Dear Ms Gibson,
RE: 1 Lawson Square Redfern 2016

We refer to your email of 10 February 2016 wherein you request further consideration and a response to the review by the Department of Planning and Environment to the Section 96 drawings (Issue C) lodged with the department on the 7 December 2015. You have requested that we provide a response to comments raised by both Russell Hand at the City of Sydney and additional matters raised by the Department of Planning and Environment.

SK - 03

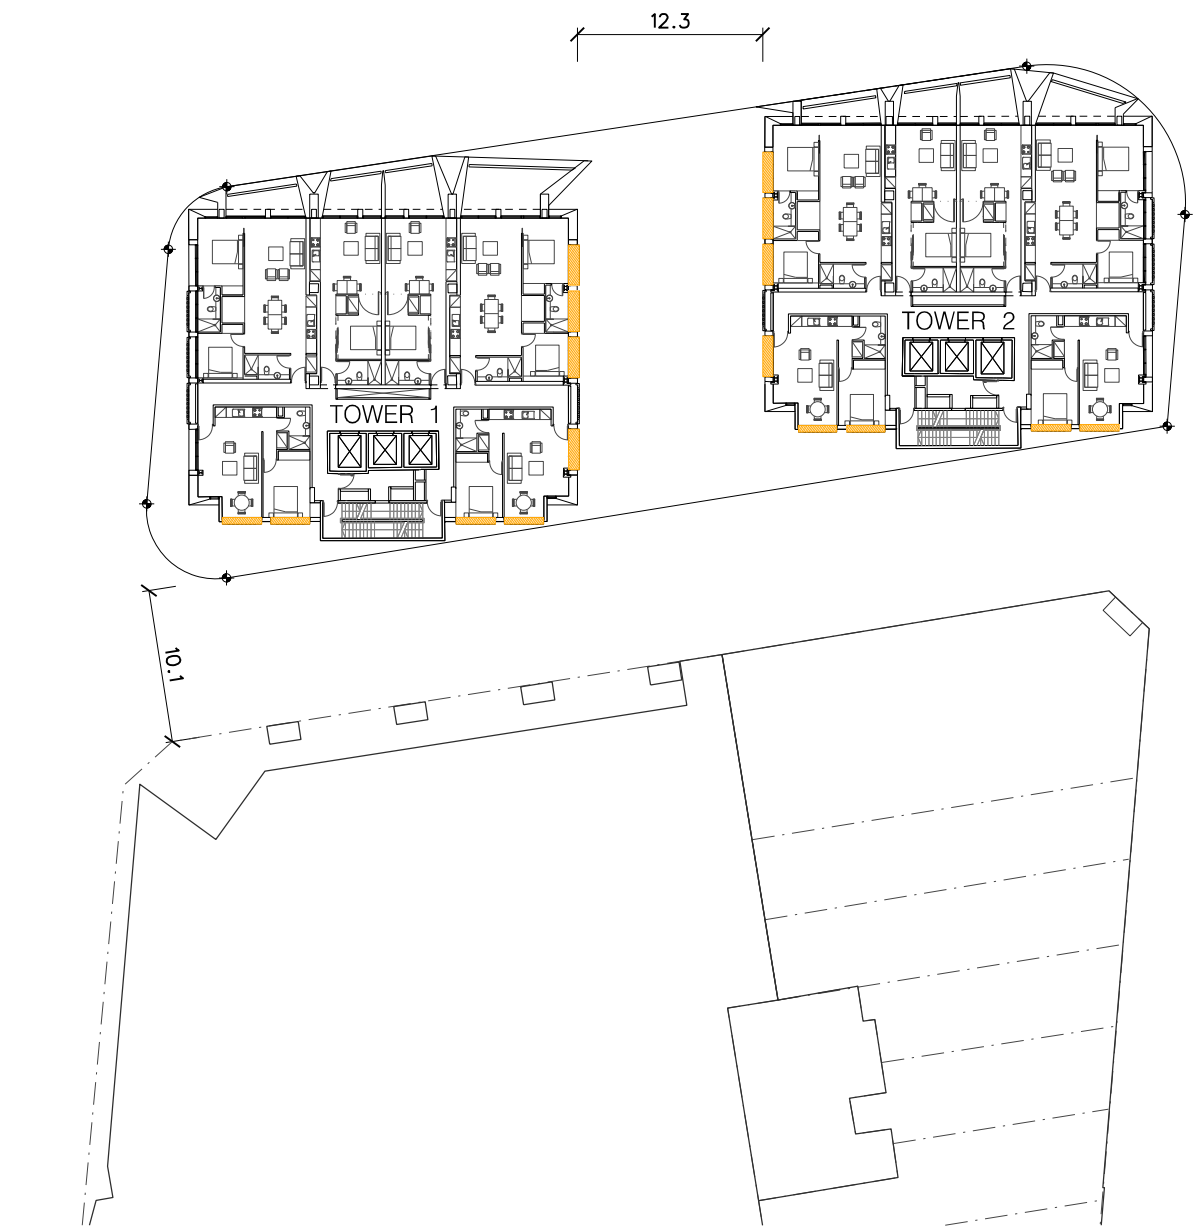
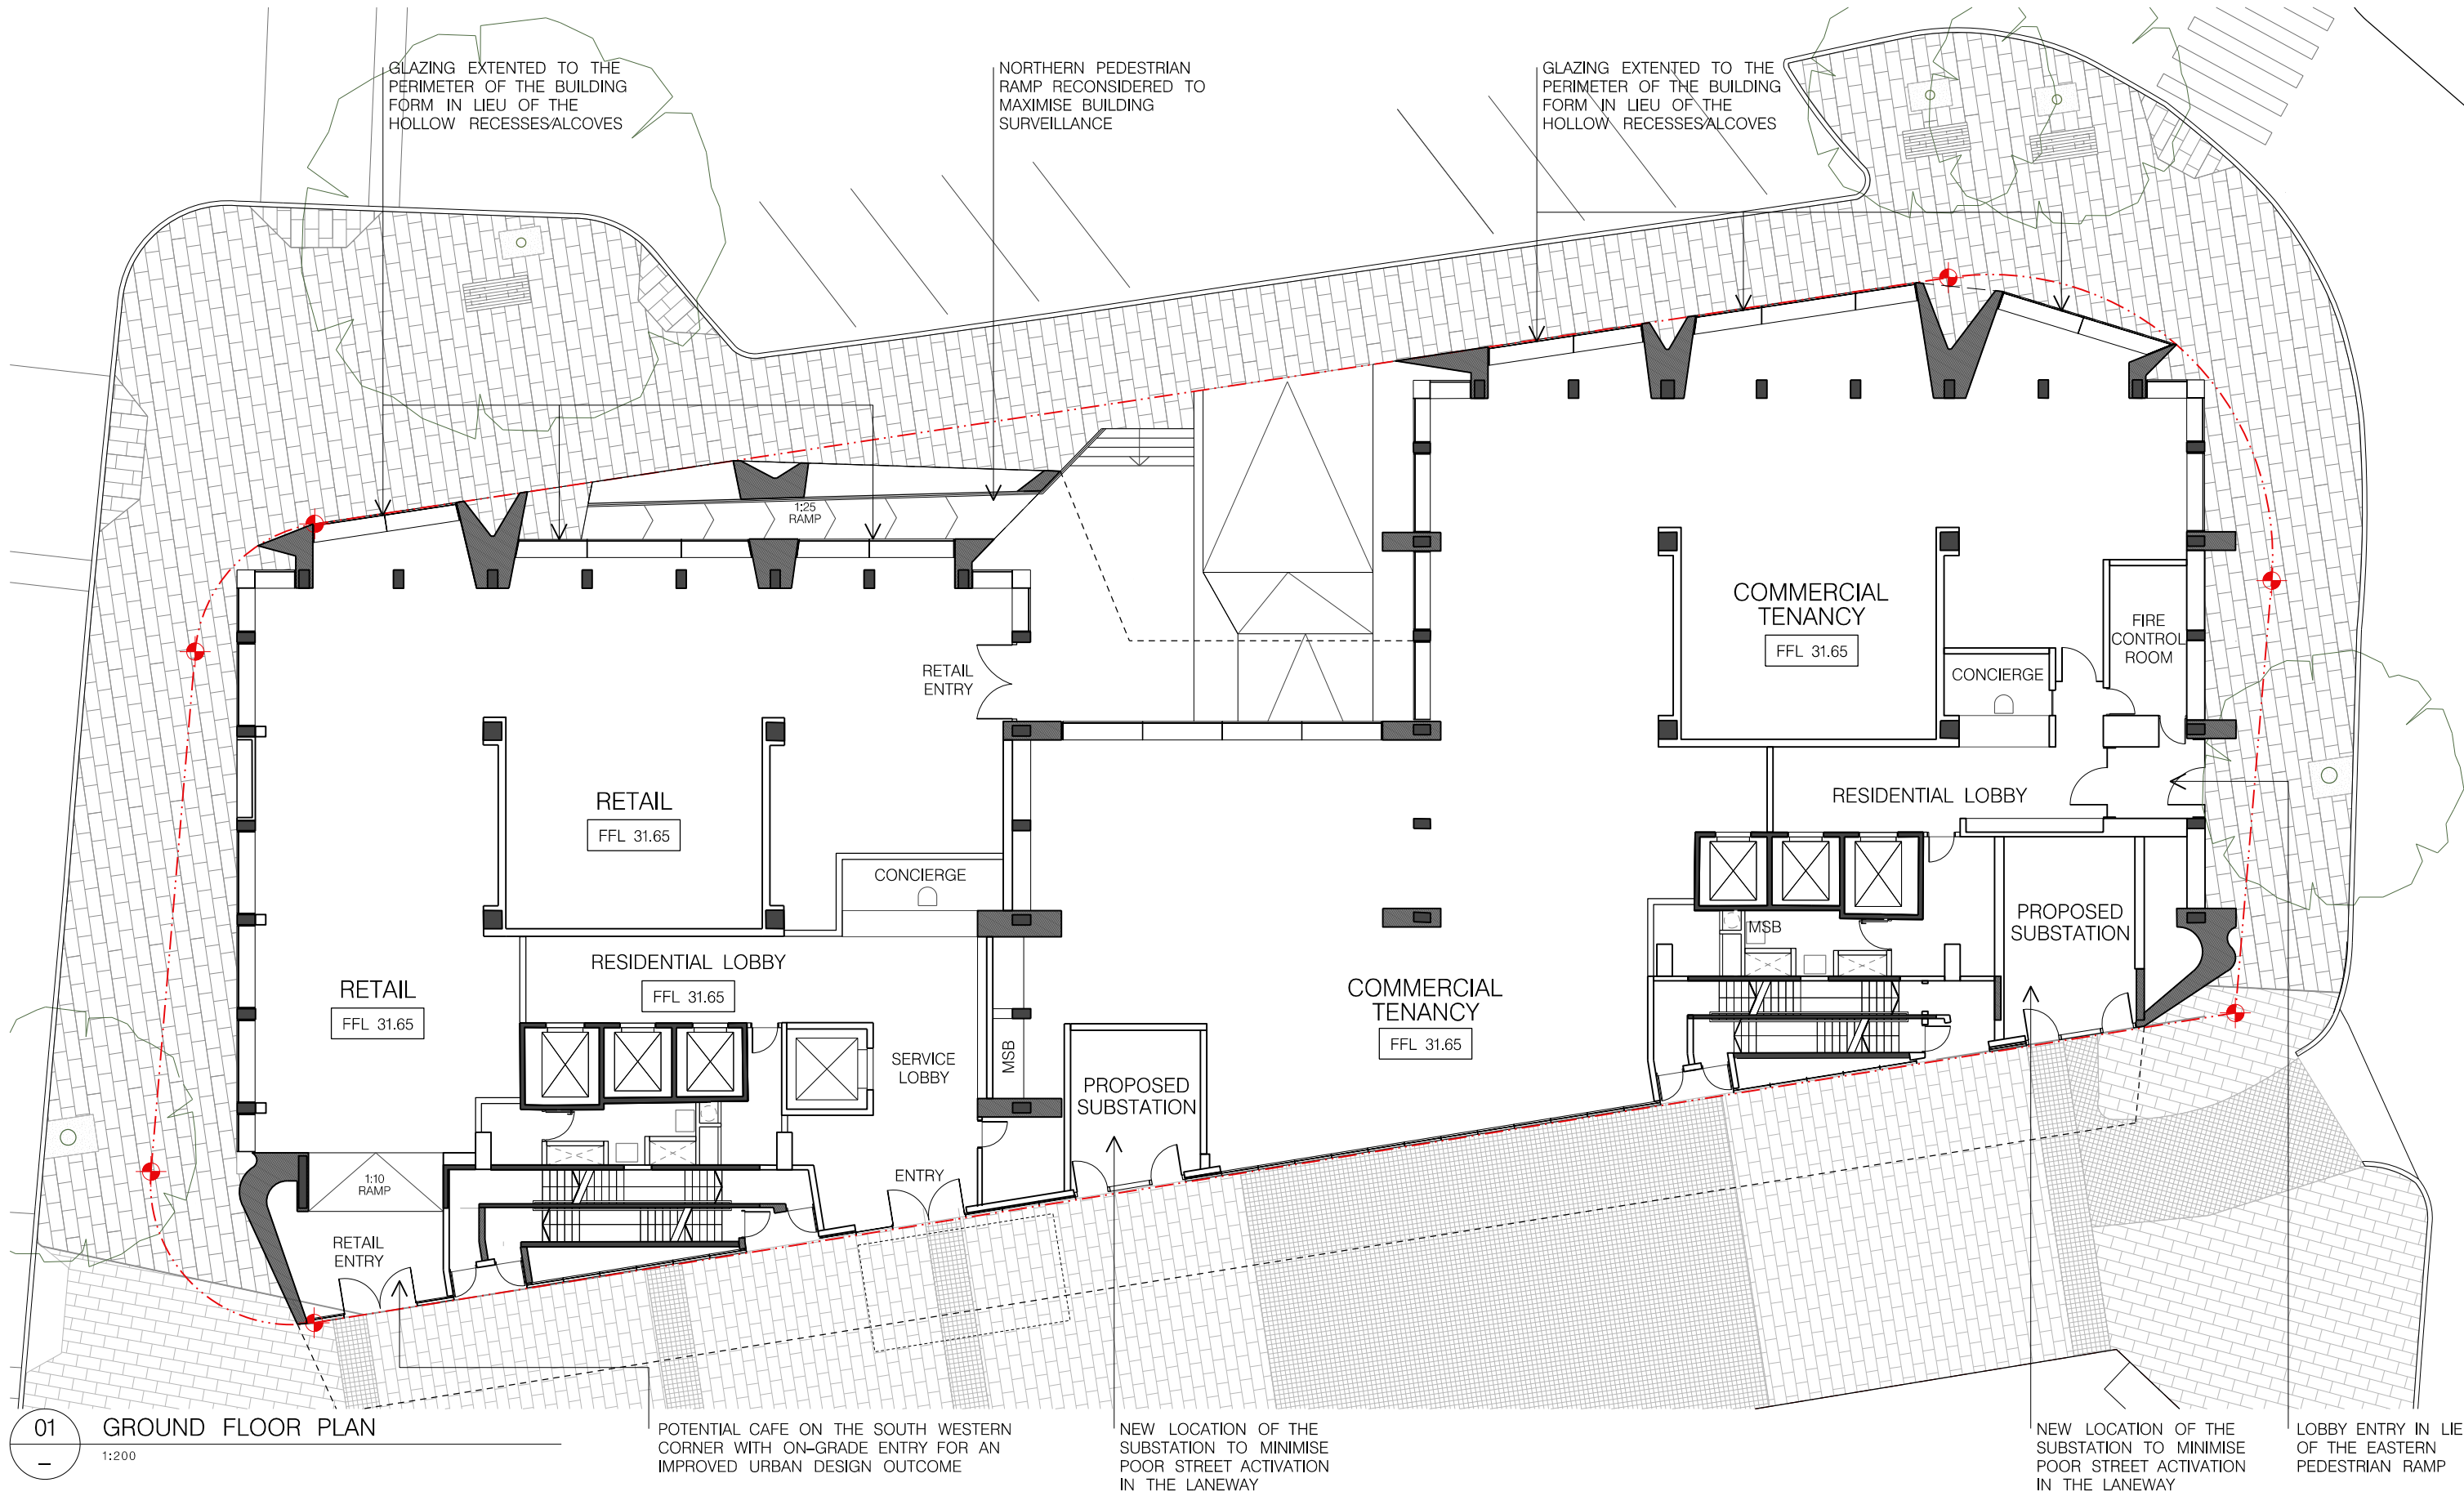
- 1. The Department is requested to review visual privacy between the two towers. Screening has been removed between the towers and there are habitable rooms facing each other with windows that would not comply with building separation standards.*

3. *The Department shares the concerns raised by Council regarding reduced privacy between the two towers. Details of the proposed privacy measures should be submitted in order to demonstrate acceptable levels of privacy can be achieved between the two towers.*

Response: Screening between towers has been reinstated to the proposed development. The proposed screens are made from Glass Reinforced Concrete (GRC) and have a similar effect as the currently approved concrete blockwork screening. The GRC screens are utilised throughout where visual privacy between towers and neighbouring buildings is required. Please refer to drawing SK-03 for further detail.
